**KIRKLEES METROPOLITAN COUNCIL
INVESTMENT & REGENERATION SERVICE**

**DELEGATED DECISION TO DETERMINE APPLICATIONS FOR
CONSENT, AGREEMENT OR APPROVAL REQUIRED BY CONDITION**

Reference No: 2020/44/92342/E

Site Address: Former North Bierley Waste Water Treatment Works,
Oakenshaw, BD12 7ET

Figure 1 – Proposed Management Strategy

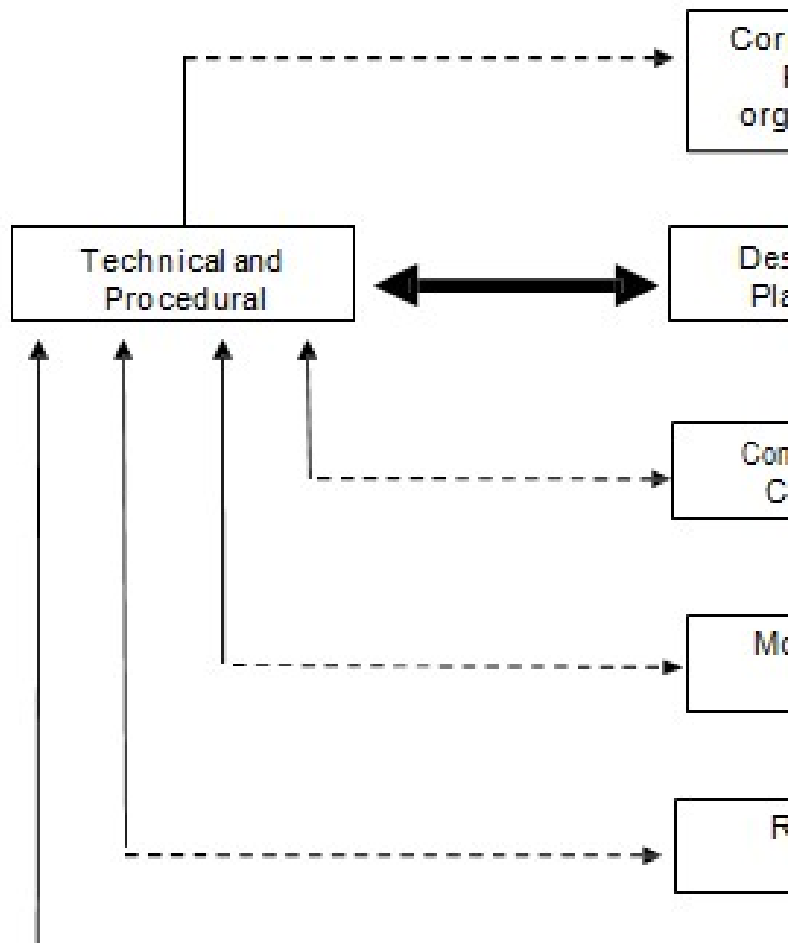
3. Figure 1 Proposed Management Strategy in the Plan is only partly legible and therefore meaningless. **RESPONSE:** A further copy was provided in full as detailed above.
